**RE: PLANNING APPLICATION 3/2023/0186 – MARYLEBONE FARM, BOWLAND GATE LANE, WEST BRADFORD BB7 4TL**

I write in my capacity as Clerk to West Bradford Parish Council. As a statutory consultee, the Parish Council always seeks to balance the need for any development (whether in a residential, agricultural or employment context) against the wider residential amenity of the village. The above application has been considered in detail at the meeting of the Parish Council held on 29 March 2023, and as a result I have been asked to submit the following observations on members' behalf.

Project: Marylebone Farm		Title: Ground Floor Plan	Scale: 1:50 @ A1
Drawn: HB	Checked: JM	Status: Information	Drawing No: 209-JMA-B1-00-P-A-022200
Details: E 27.02.23 Issue for Information

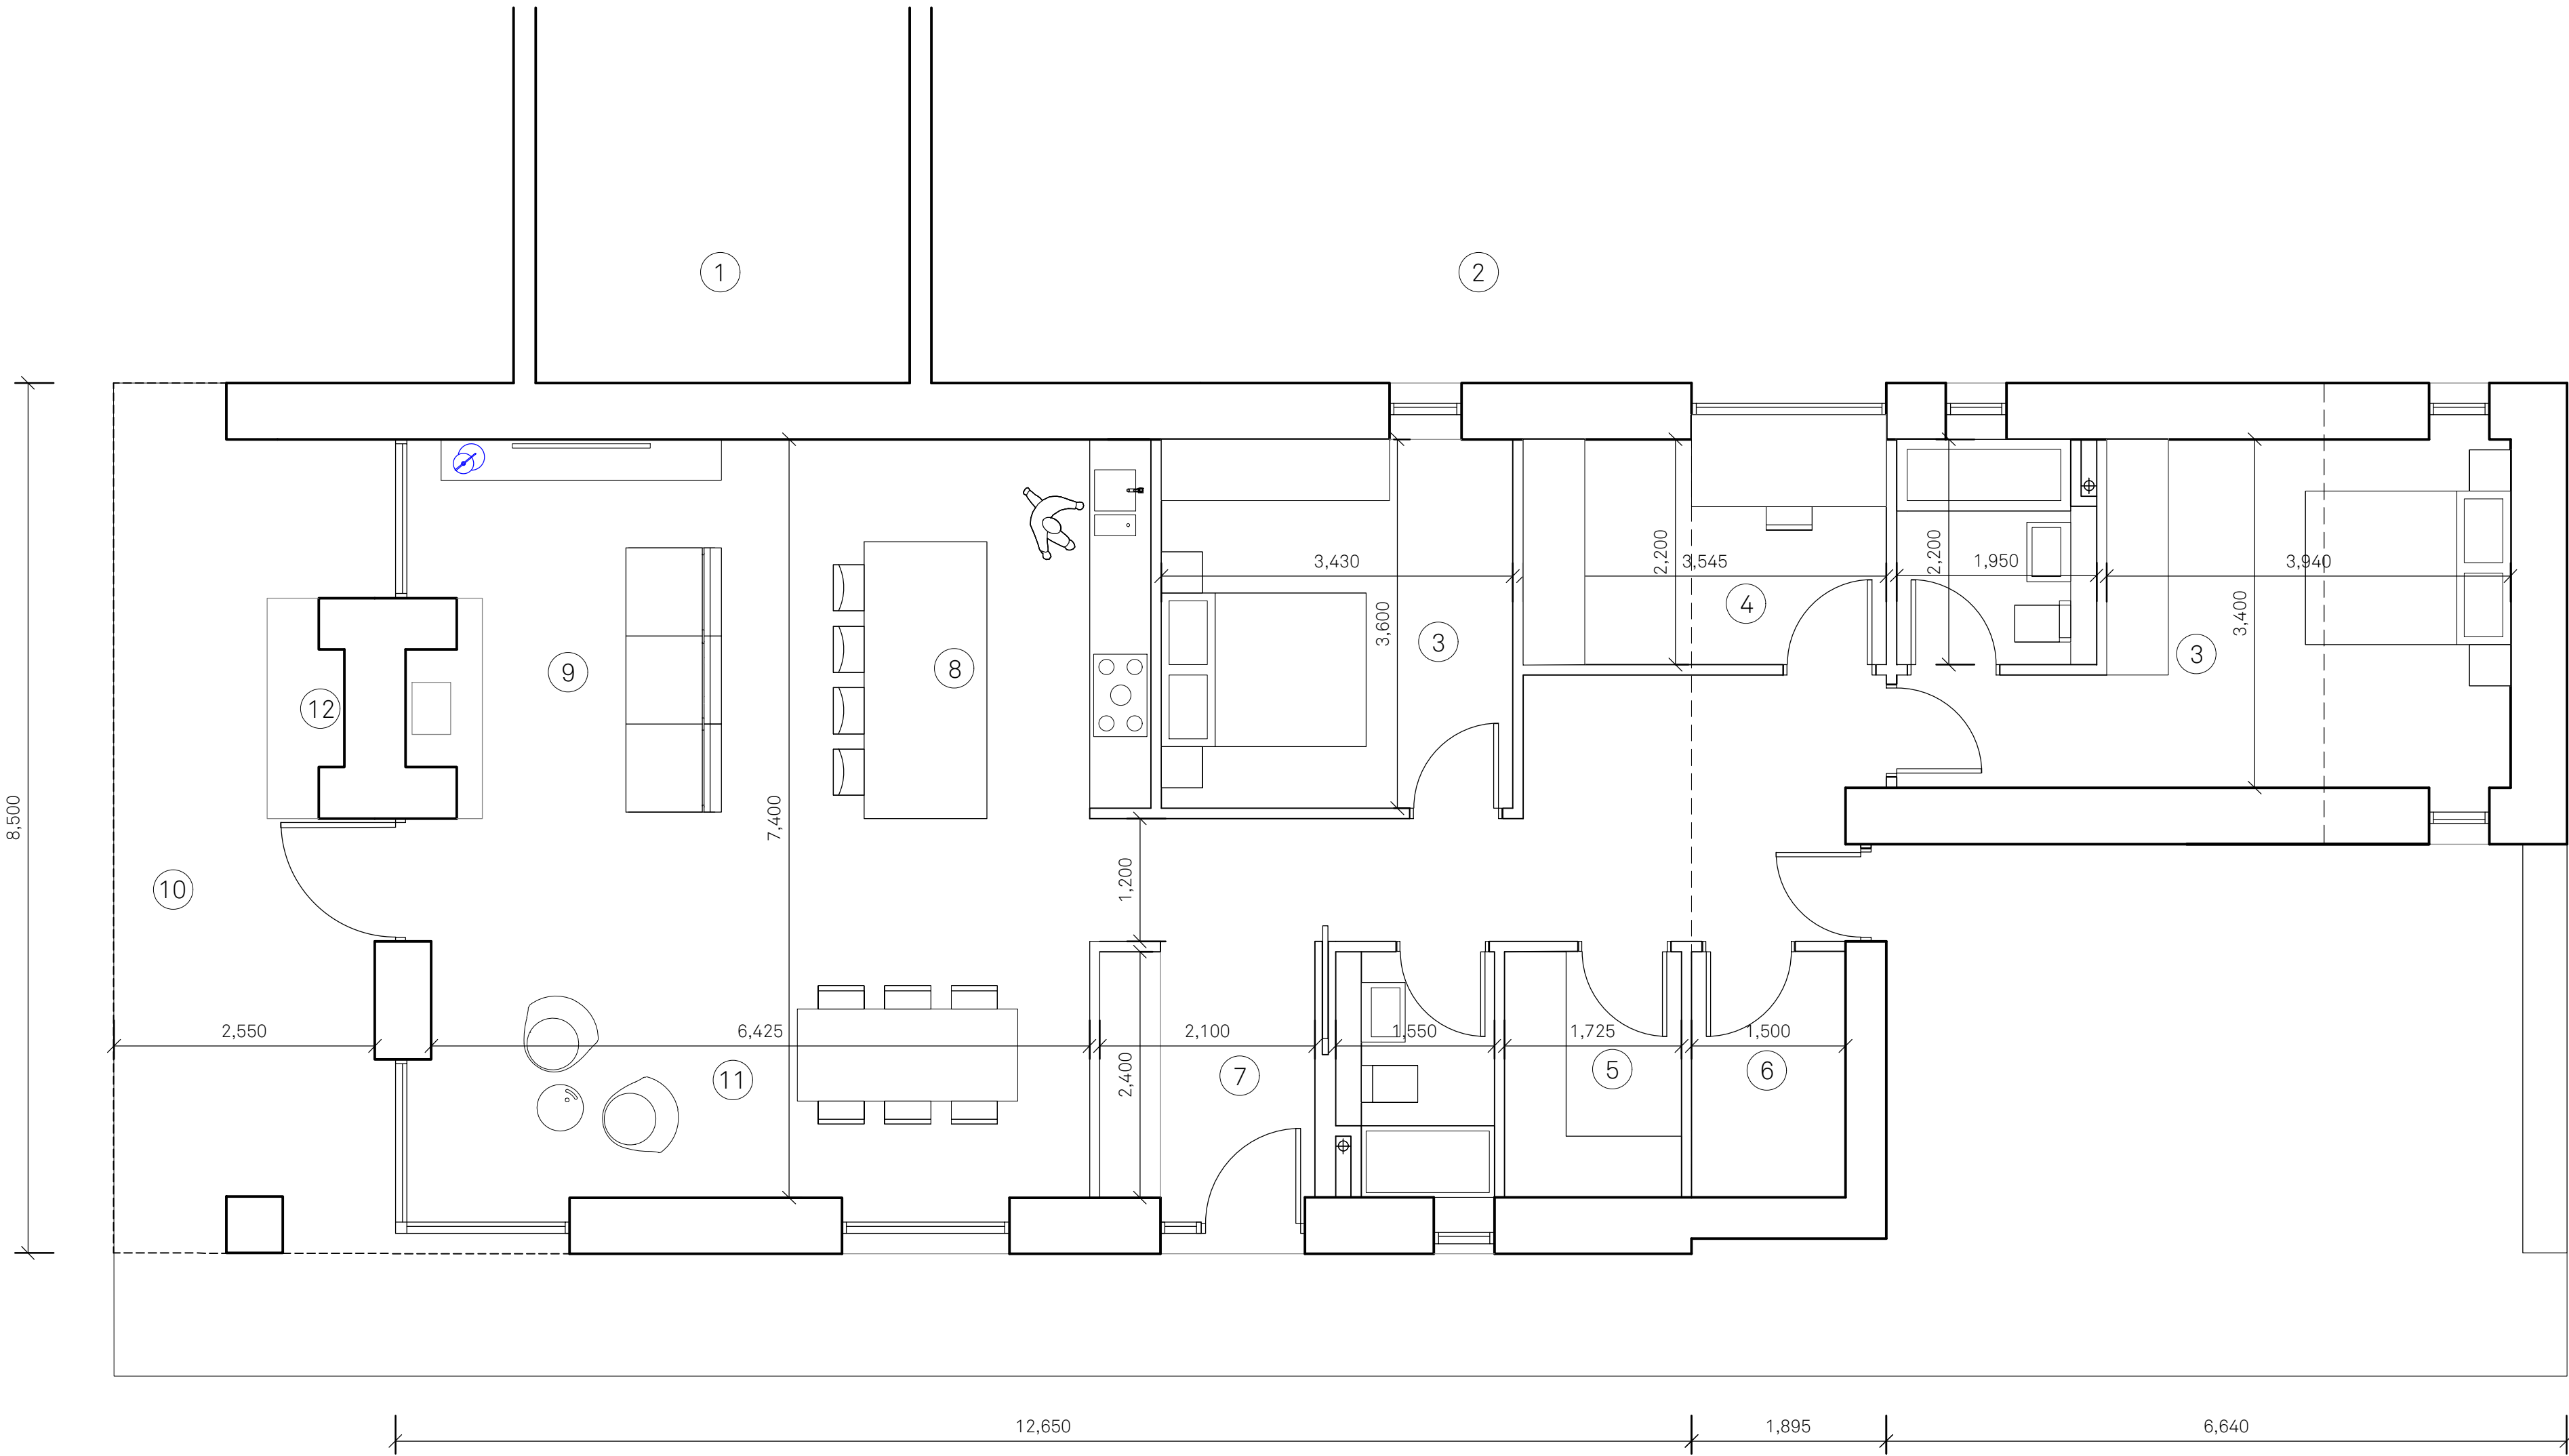
However, in members' opinion, the impact of the proposed new design would not be dissimilar to that put forward in the 2022 application. This is demonstrated by the extracts below, taken from the applicant's plans, which appear to suggest that changes to the original design are in fact minimal:[3/2022/0446](#):

3/2023/0186:

If the relevant test is one of “modesty”, members remain unconvinced that the new design will meet this any more than the previous submission.

Project: Marylebone Farm		Title: Roof Plan	Scale: 1:50 @ A1
Drawn: HB	Checked: JM	Status: Information	Drawing No: 209-JMA-B1-RF-P-A-022201
Details: A 27.02.23 Issue for Information

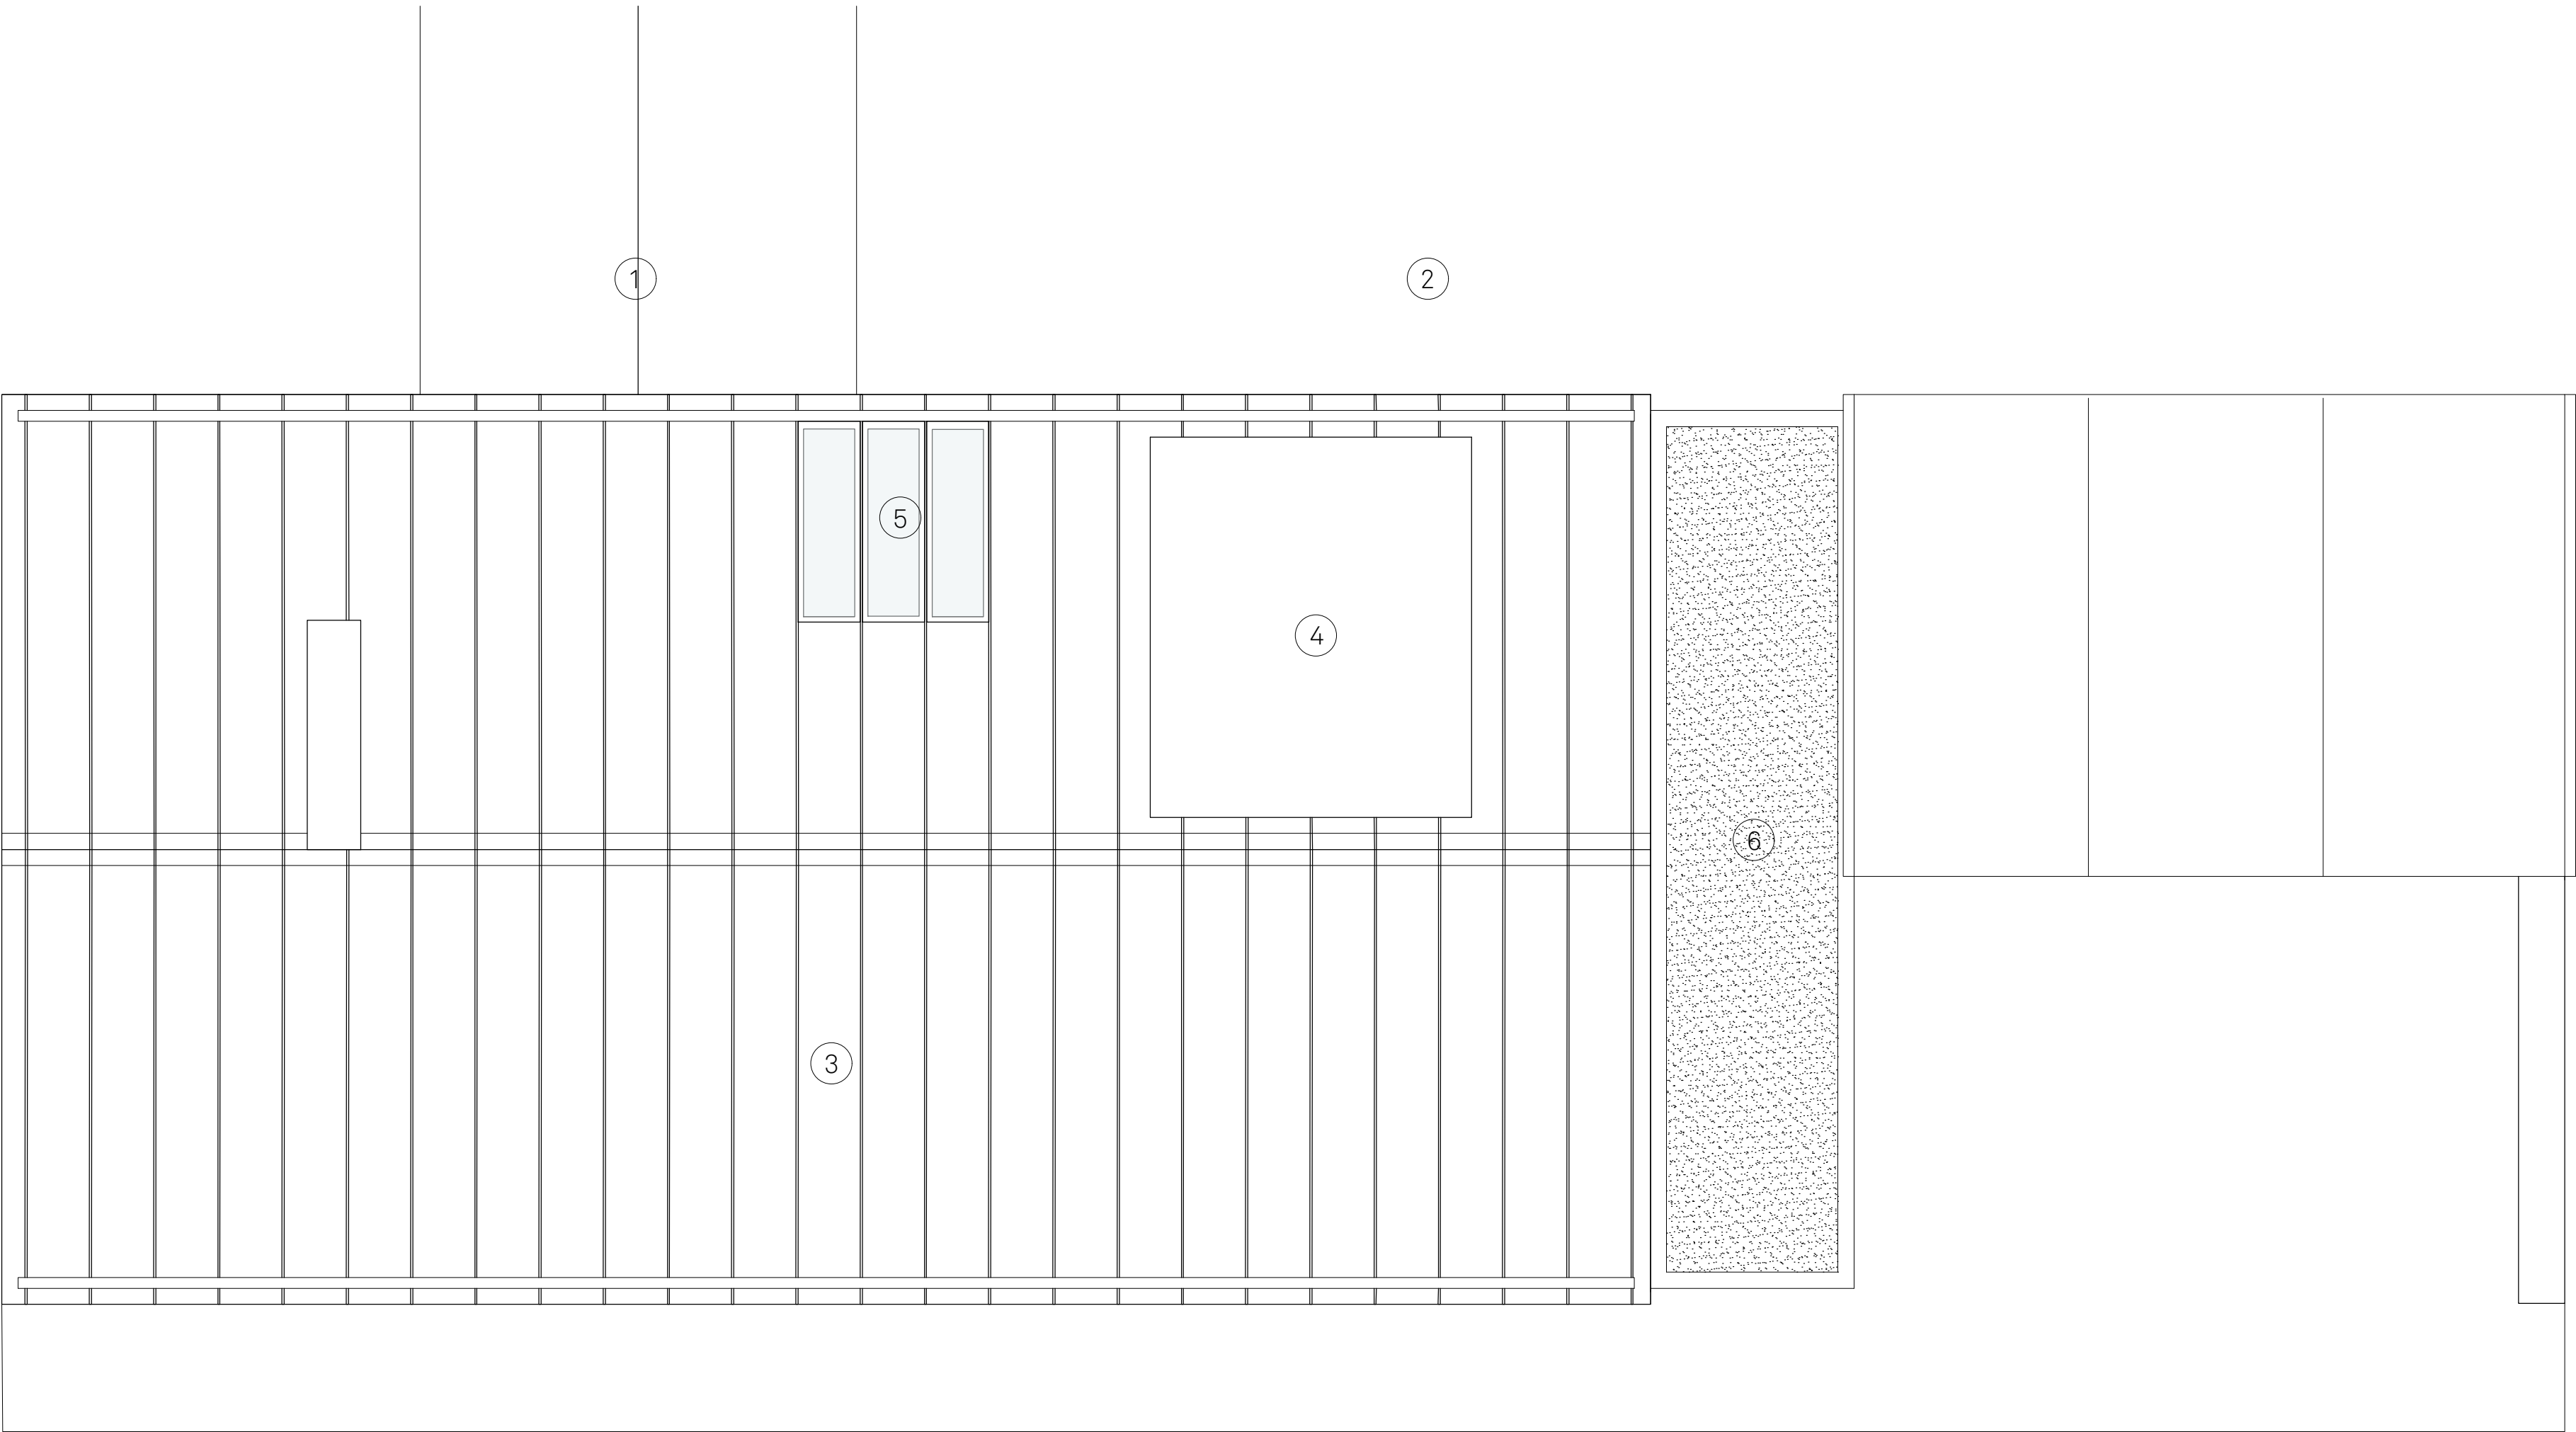
In contrast, however, members would strongly continue to assert that the presence of a zinc roof and cladding is not in keeping with the traditional design of buildings in the vicinity, nor with the wider appearance of the Forest of Bowland AONB. In line with its previous comments, the design would be viewed more favourably by the Parish Council if the property were to be constructed of random stone and with a slate roof.
